**Consultation Response from KC,
Trees**
2021/92667 99, New North Road, Edgerton, Huddersfield, HD1 5QL
Erection of retaining wall, gate pillars and gate, alteration of existing access and new surface to drive (within a Conservation Area)
Date Responded: 05/11/21 Responding Officer: NG Responding Ref:CA32

View 1: Location Plan  
Scale 1:250

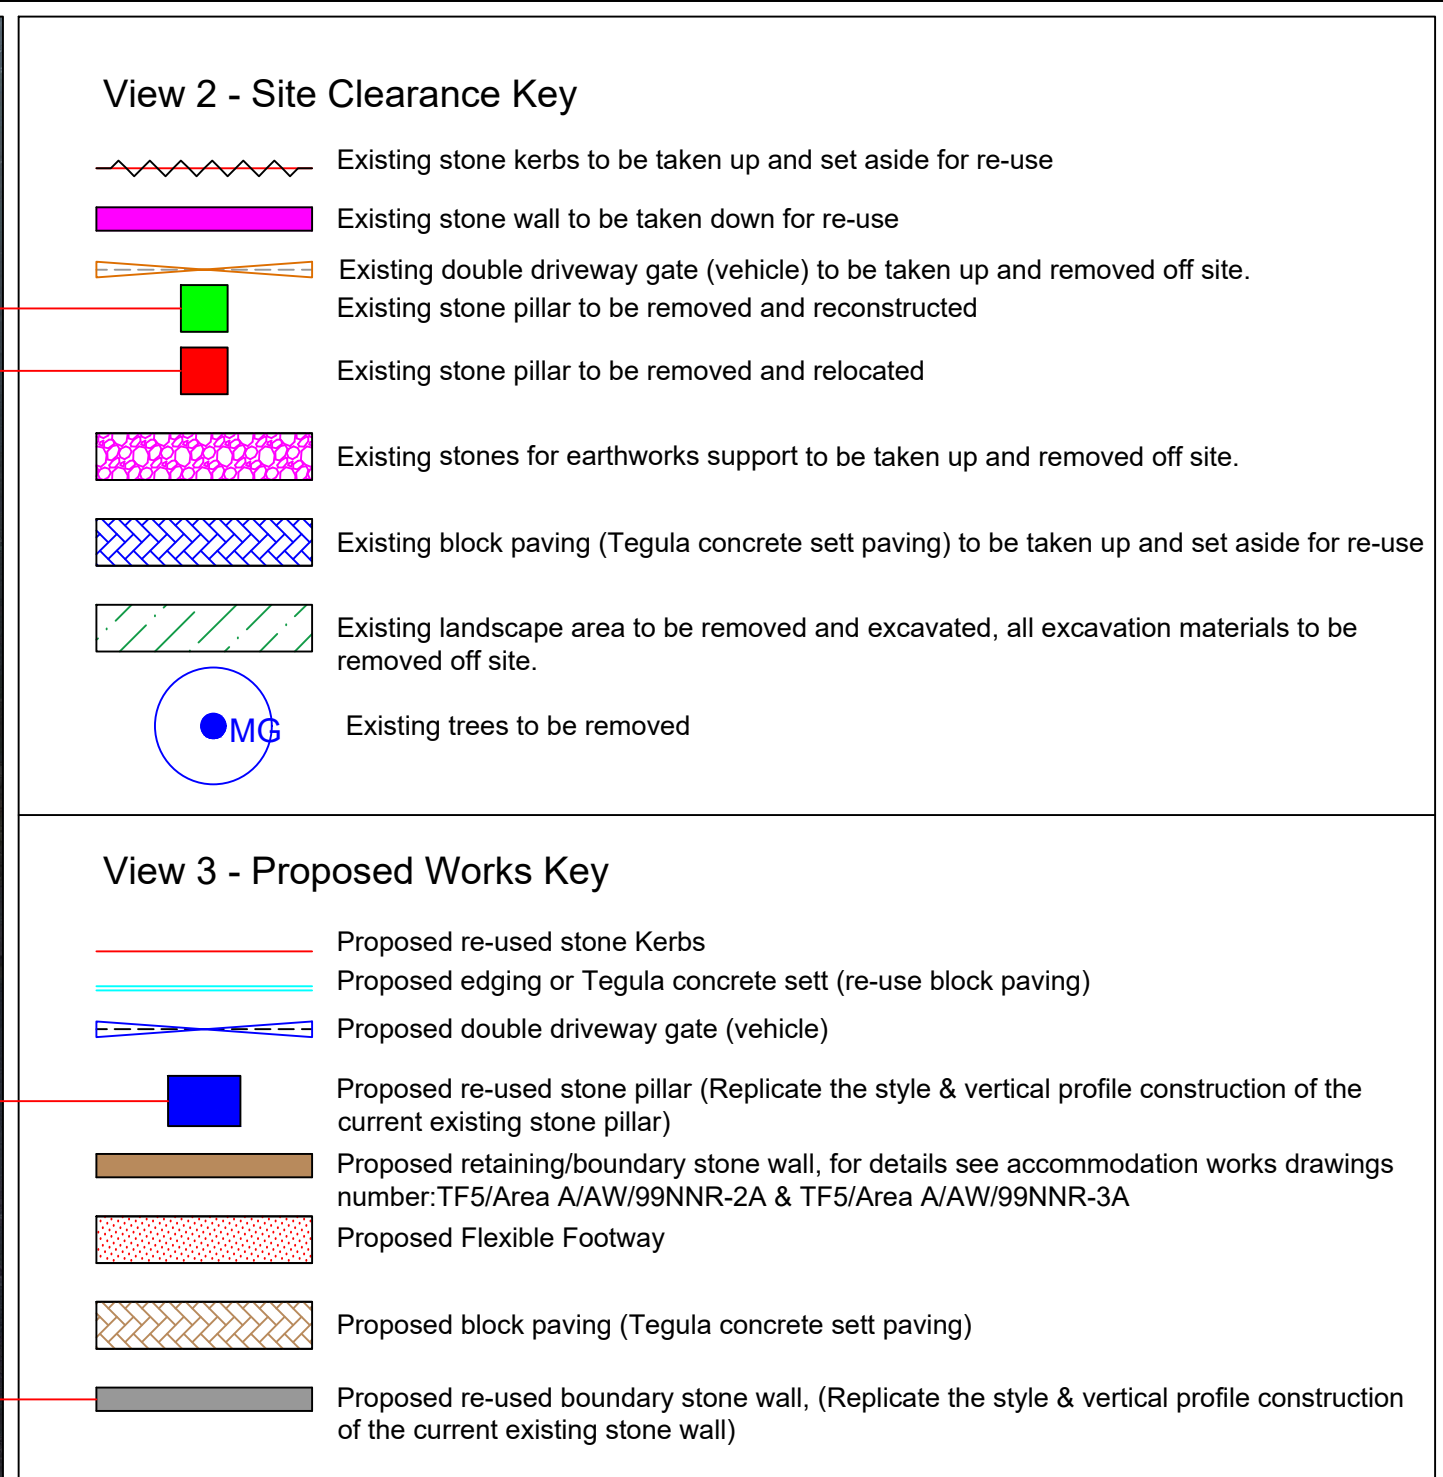
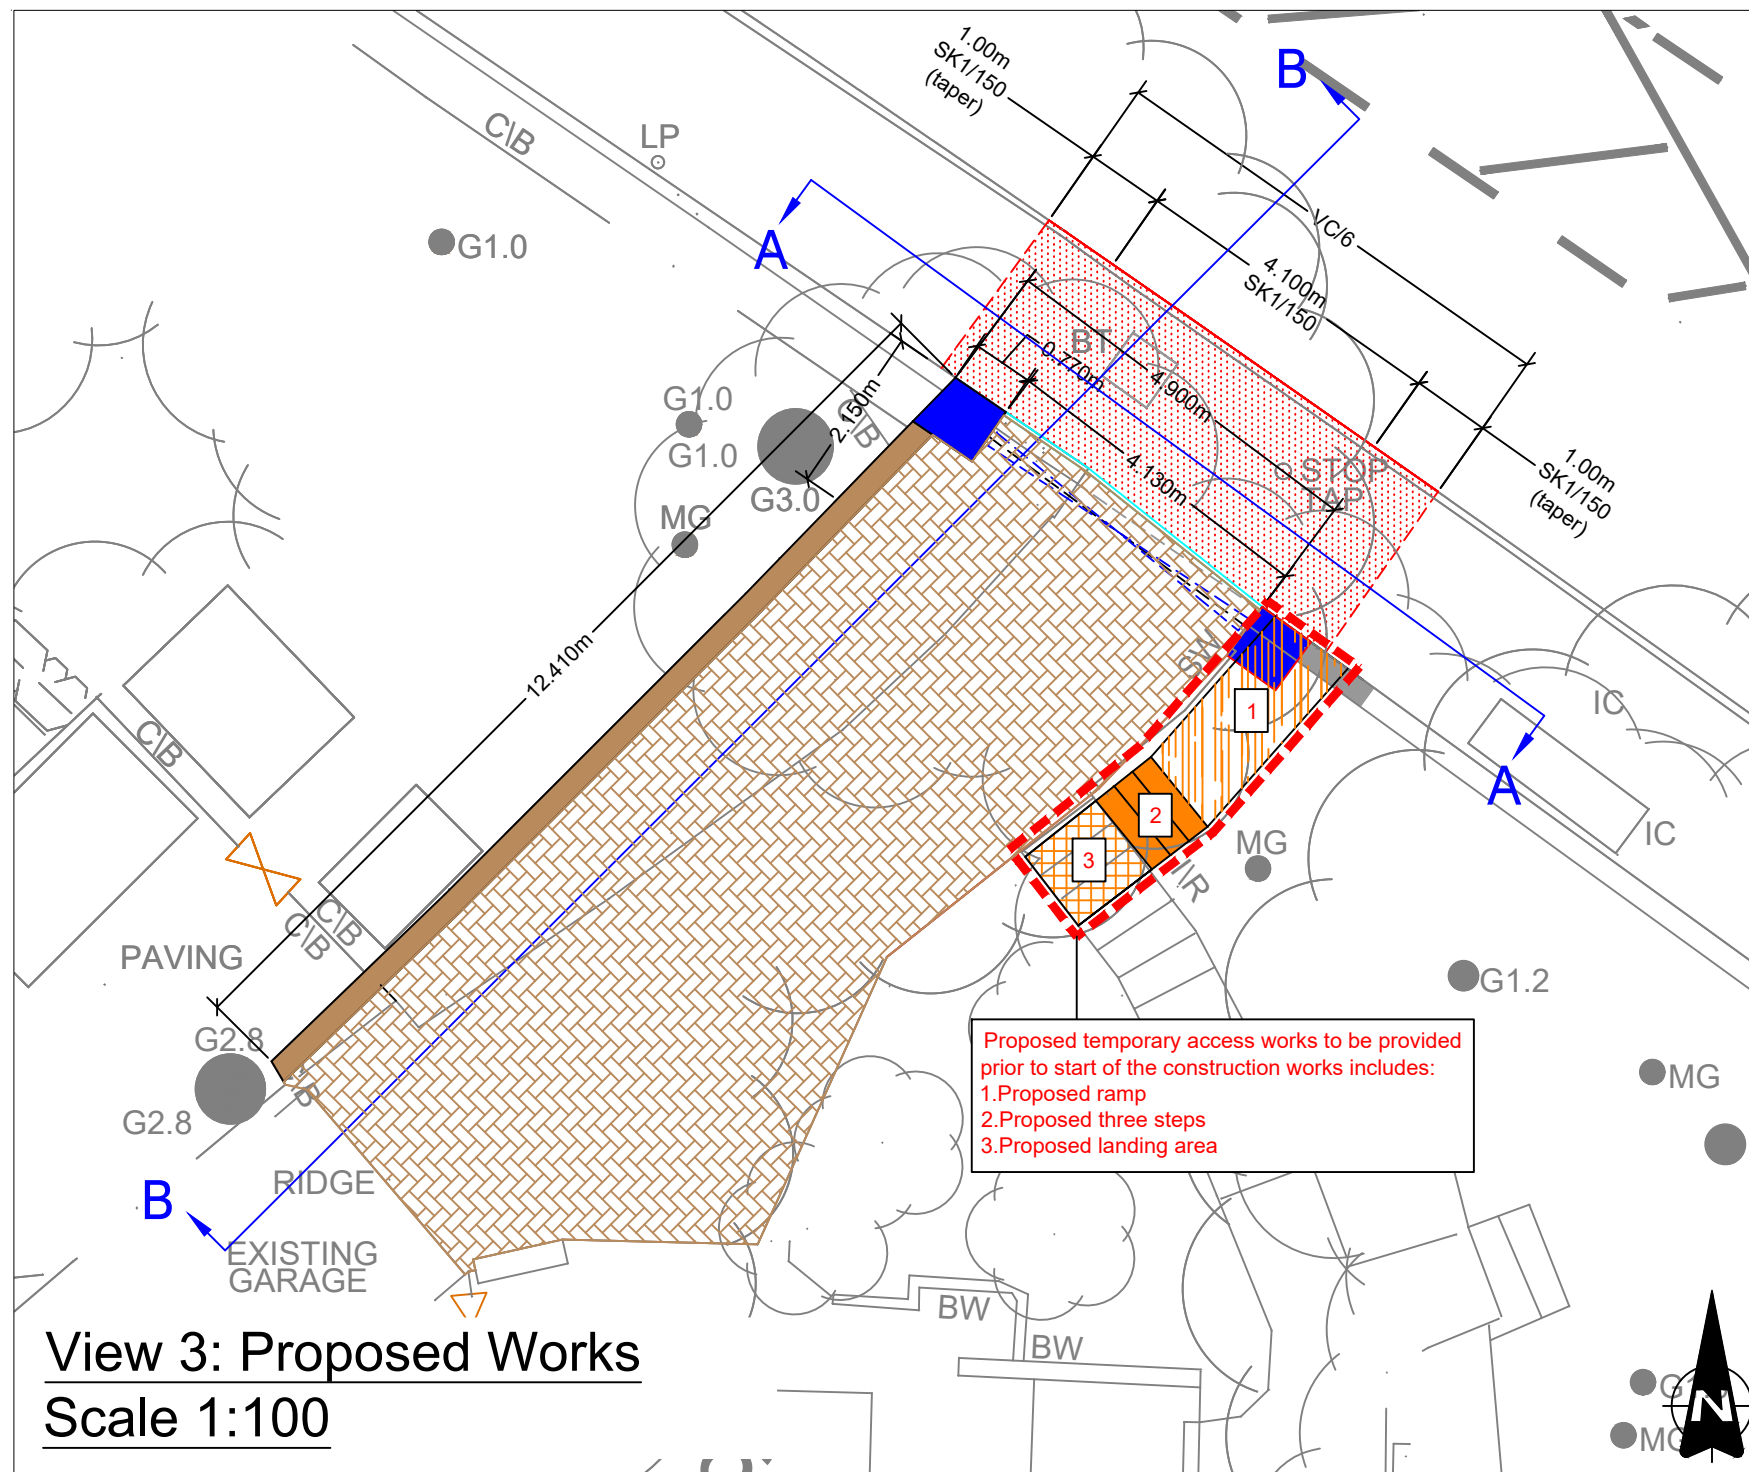
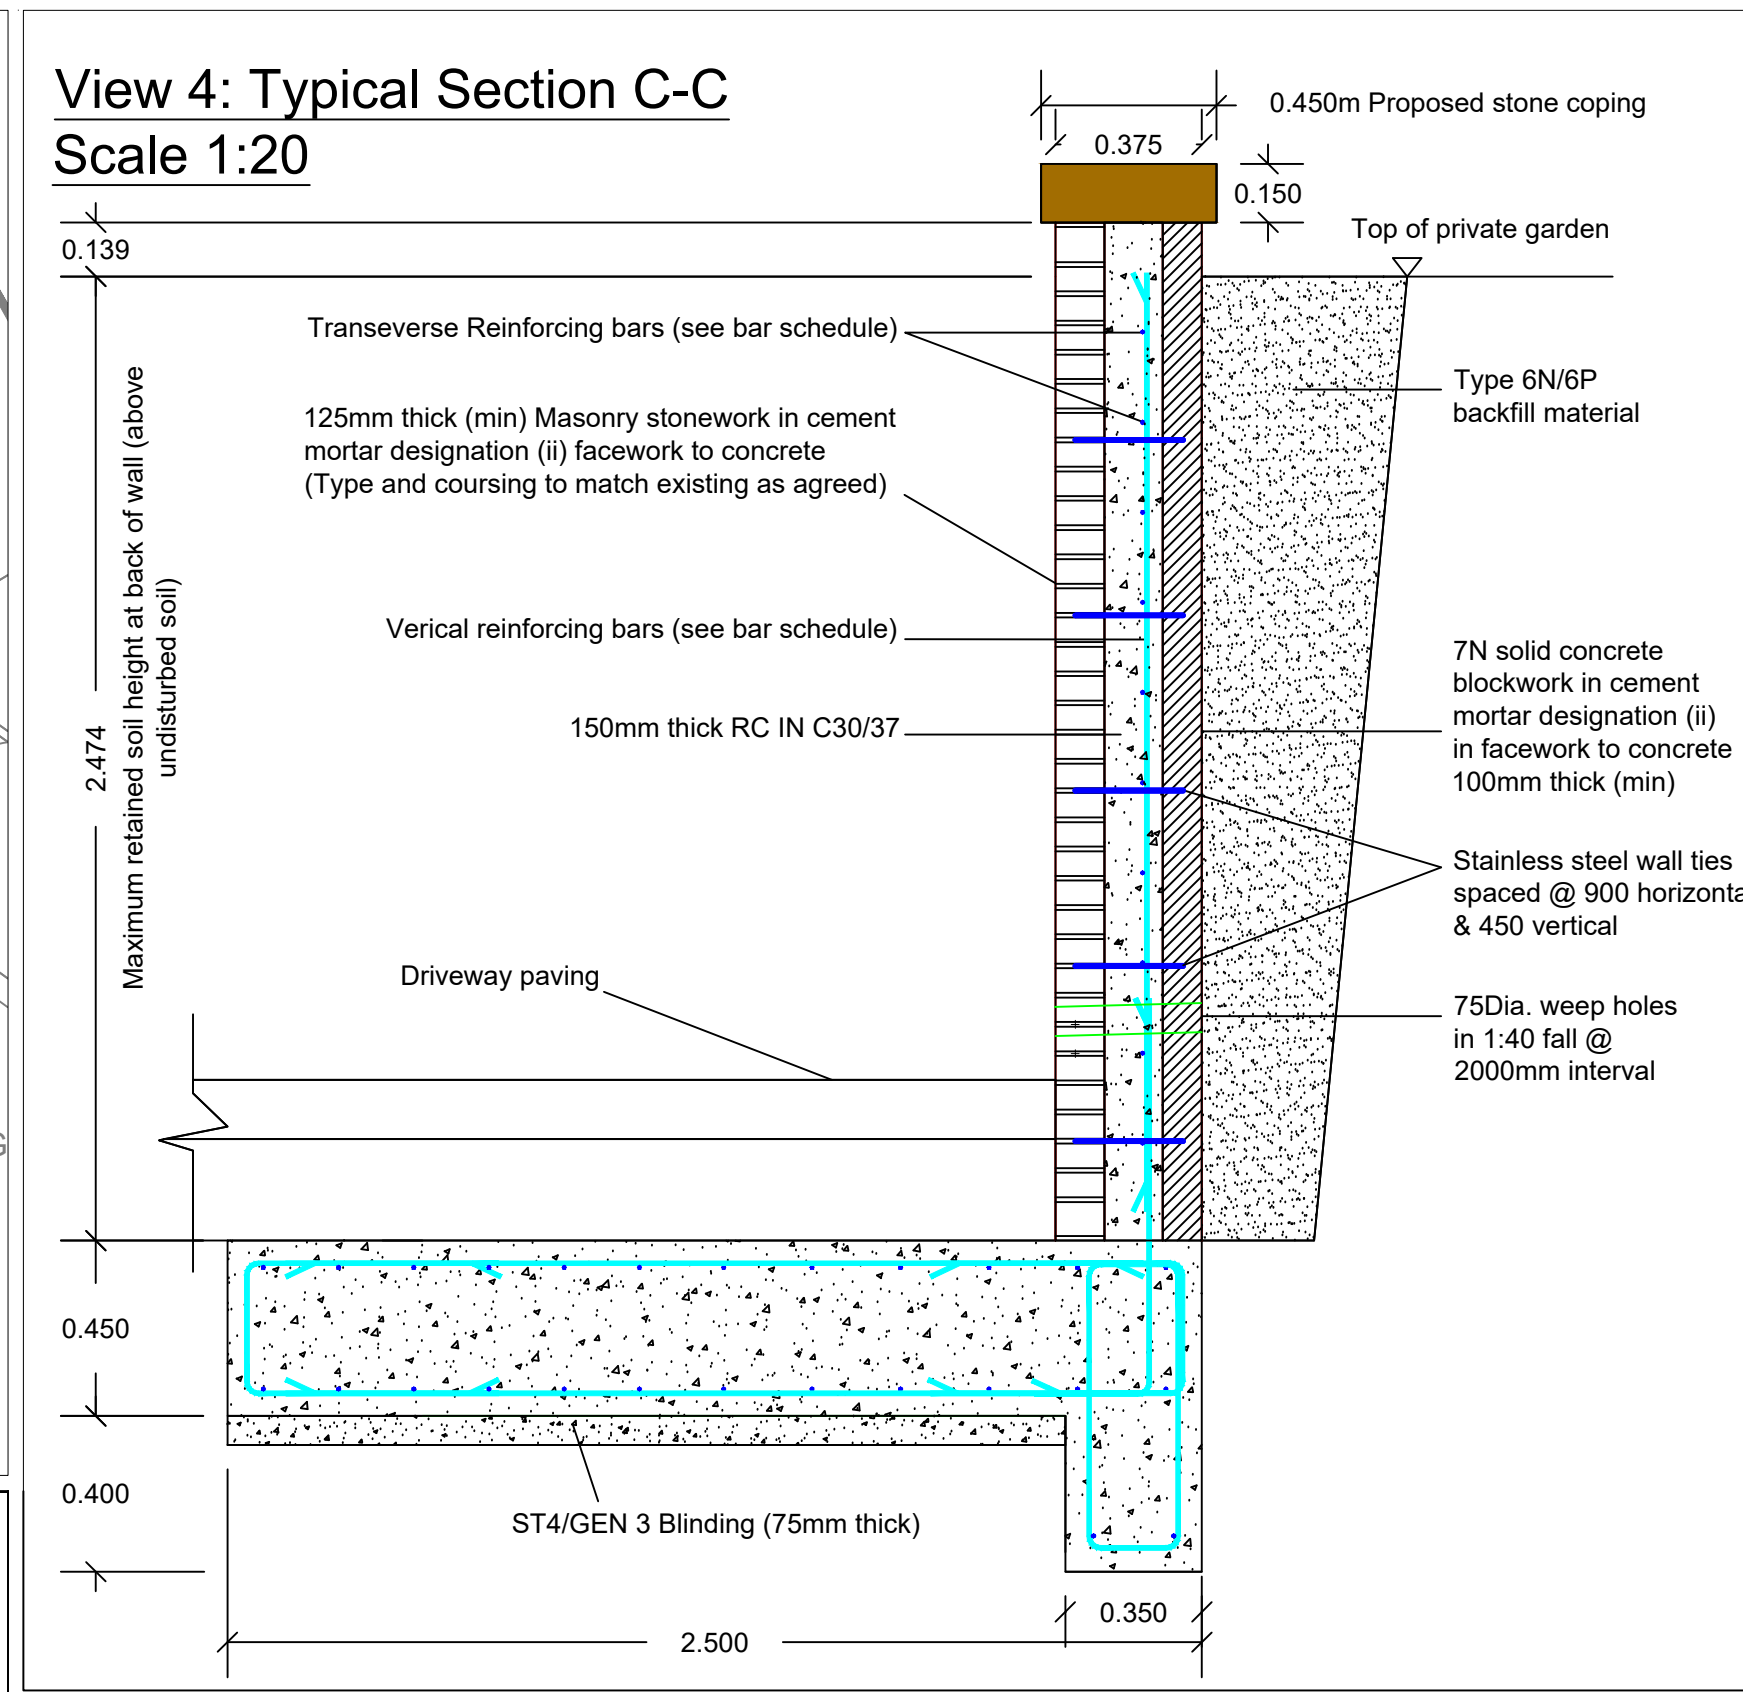
The application form does not acknowledge the trees adjacent to the site which may be affected by the proposals despite the plans showing two large tree stems of mature trees just offsite adjacent to the area to be excavated.

The proposals to widen the driveway and entrance gateway requires a significant change of ground level within the rooting area of two significant mature trees within the Edgerton Conservation Area. The proposals are likely to have a negative impact on the long term health and potentially the stability of these trees. The two trees offsite are proposed for removal as part of the application, ref 2021/92734, to widen and improve the A629.

Any consent granted under this application should be linked via condition to the A629 scheme, if possible. If that scheme does not go ahead then the work proposed in this scheme would result in the harm outlined above to offsite trees with significant public amenity which should be avoided.
